From: [REDACTED]
To: A303SparkfordtoIlchester@pins.gsi.gov.uk
Subject: Response from The Red Lion Inn for A303 Sparkford to Ilchester Dualling Scheme (TR010036)
Date: 06 March 2019 10:08:57
Attachments: [Red Lion Babcary TR010036 Response.pdf](#)

A303 Sparkford to Ilchester Dualling Scheme (TR010036) Response to Examining Authority's Written Questions by Mrs and Mrs Garrard

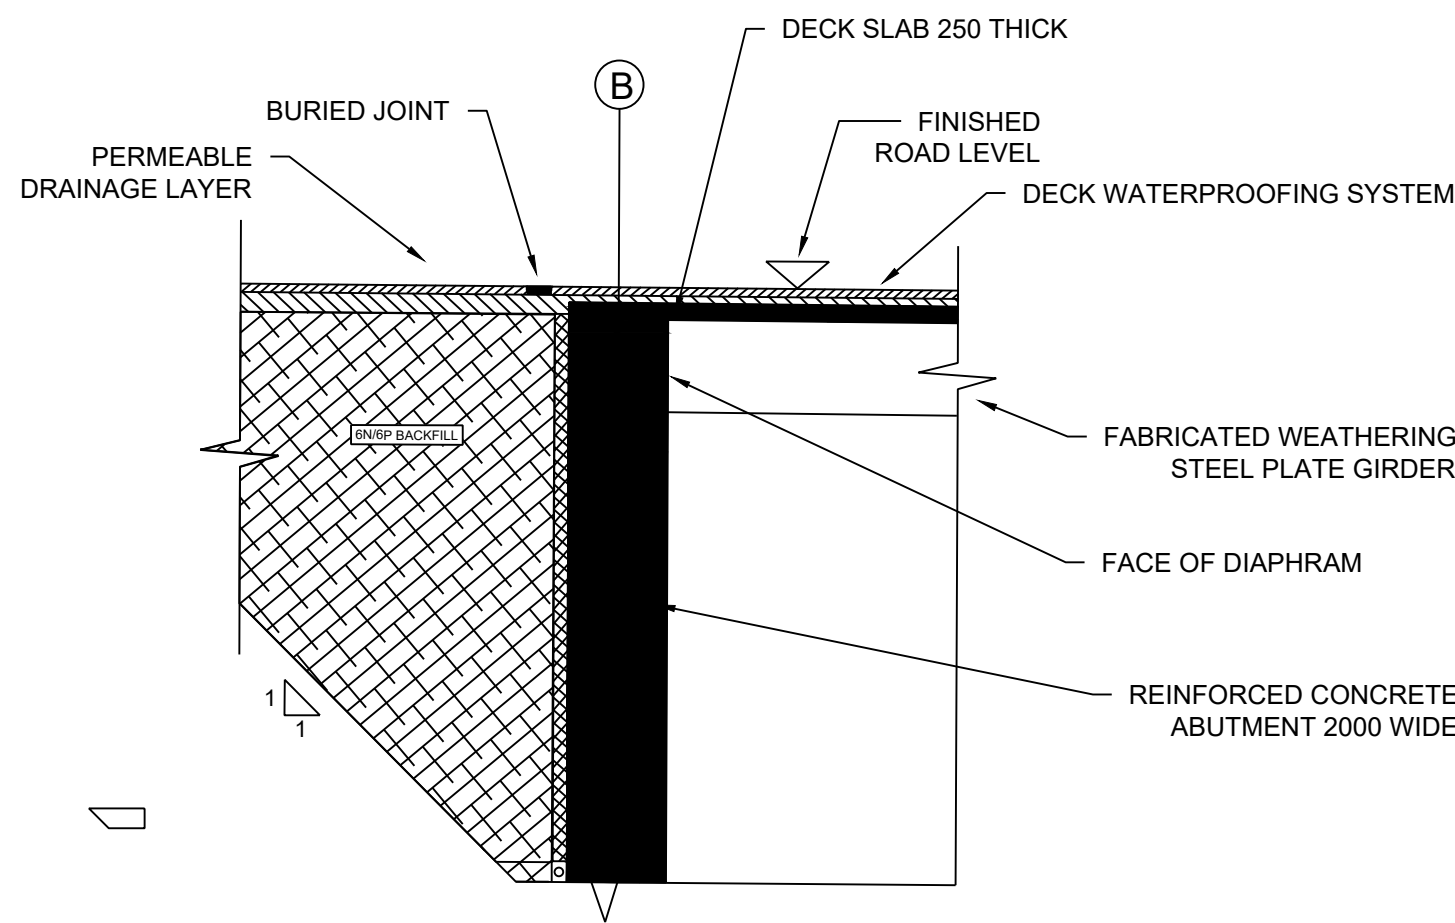
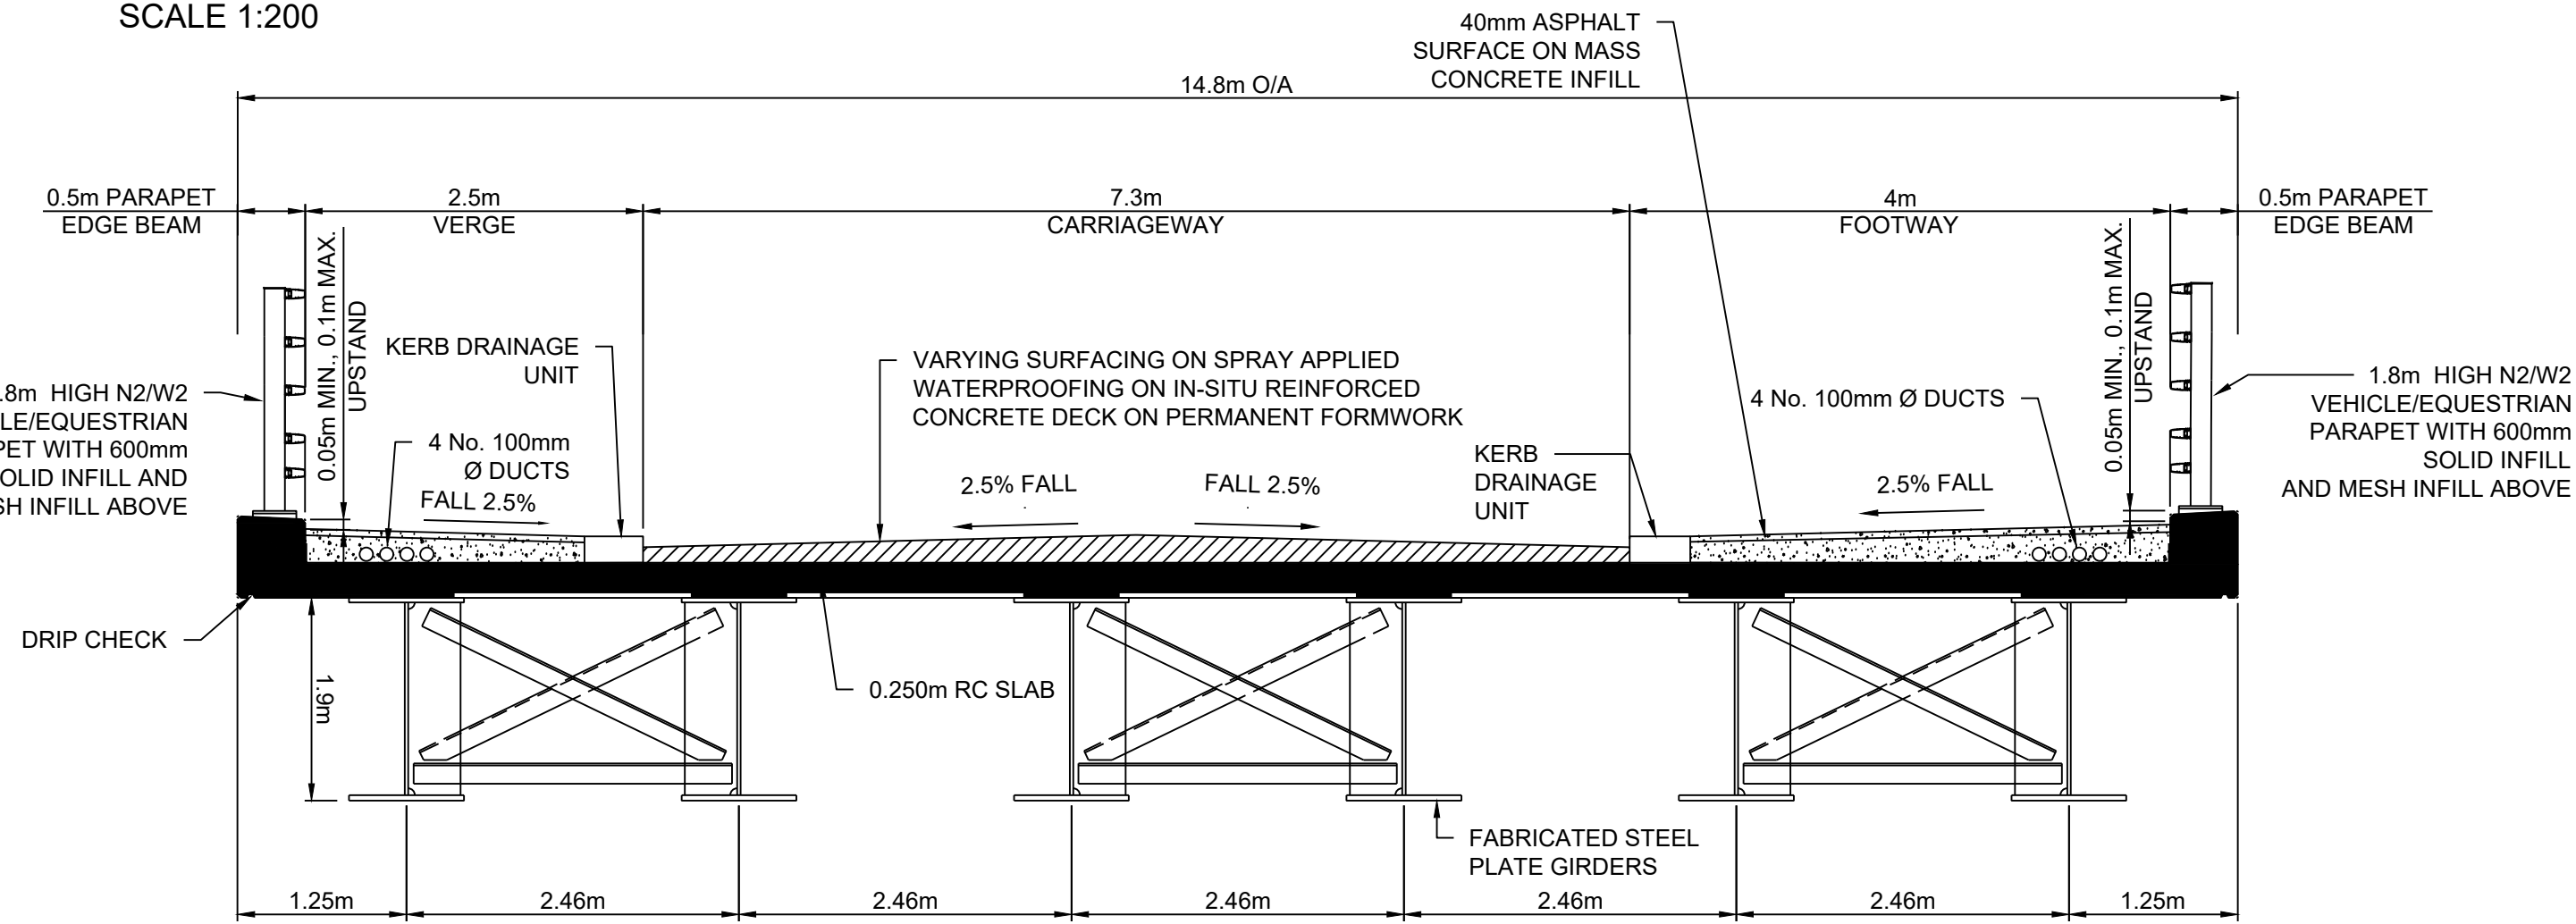
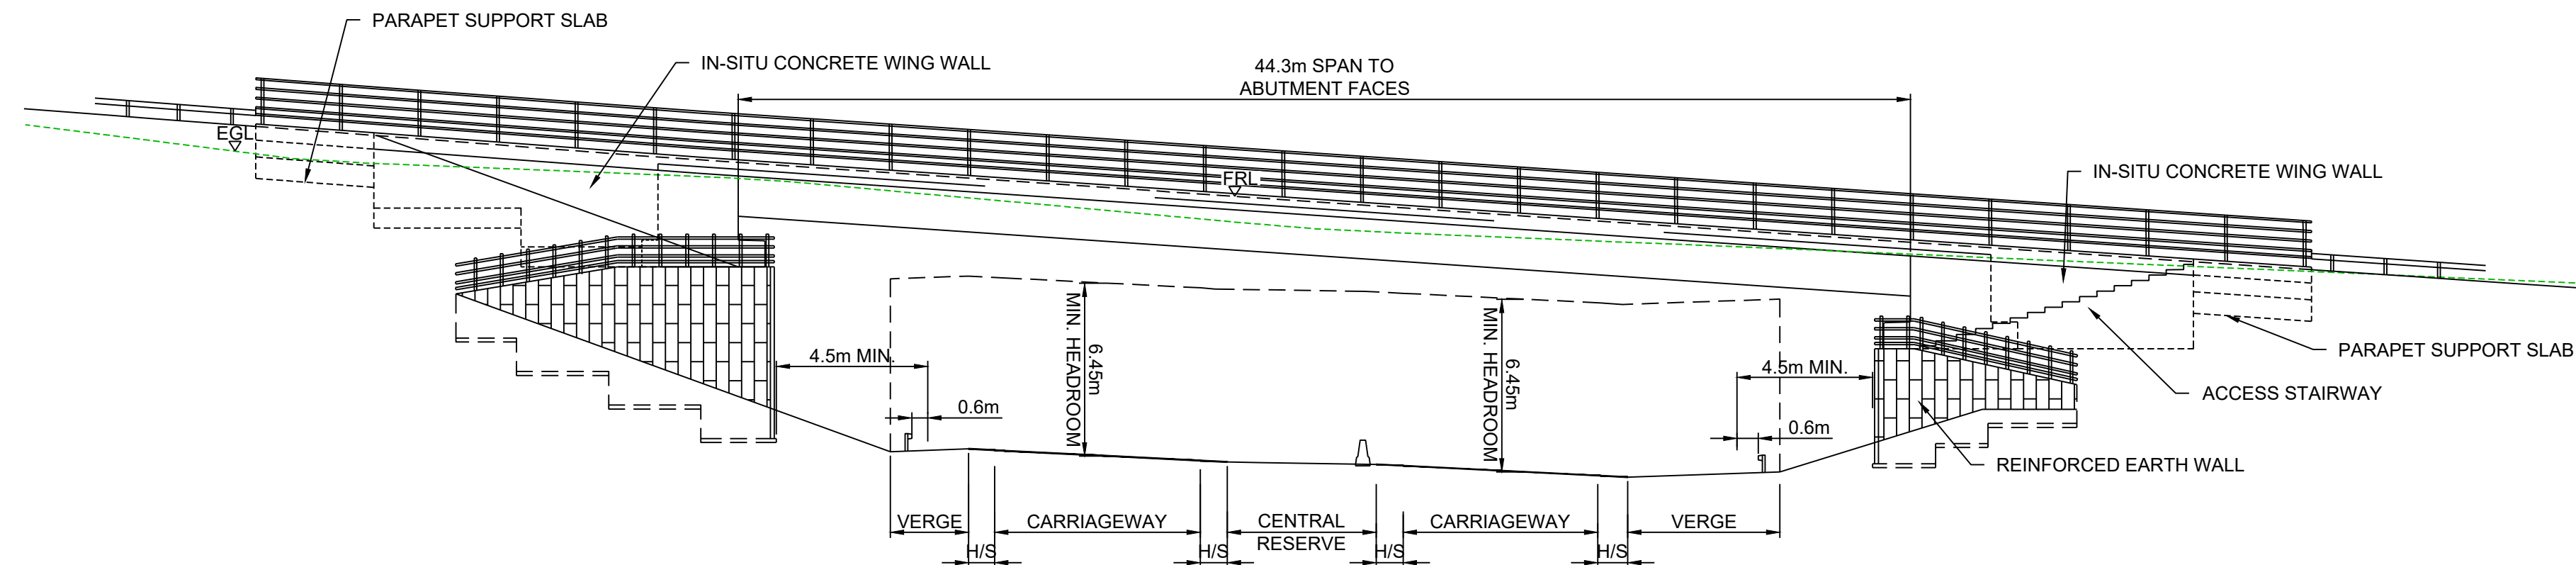
- **Explain why the village of Babcary would be cut off from the south side of the A303 given the Steart Hill overbridge appears to provide access to Steart Hill.**

The proposed scheme layout does not “cut off” the village of Babcary from the south side of the A303, for as noted by the Examining Authority there is an overbridge to Steart Hill, the proposed scheme layout adds an additional 2.2 miles (or an 8 minute journey time) for anyone travelling from the east to the west along the A303.

This additional journey time and less direct access will have a negative impact upon the viability of the Red Lion Inn, especially as the existing signage which is currently sited on the A303 will be removed and there is no intention to replace like-for-like signage anywhere along the proposed route.
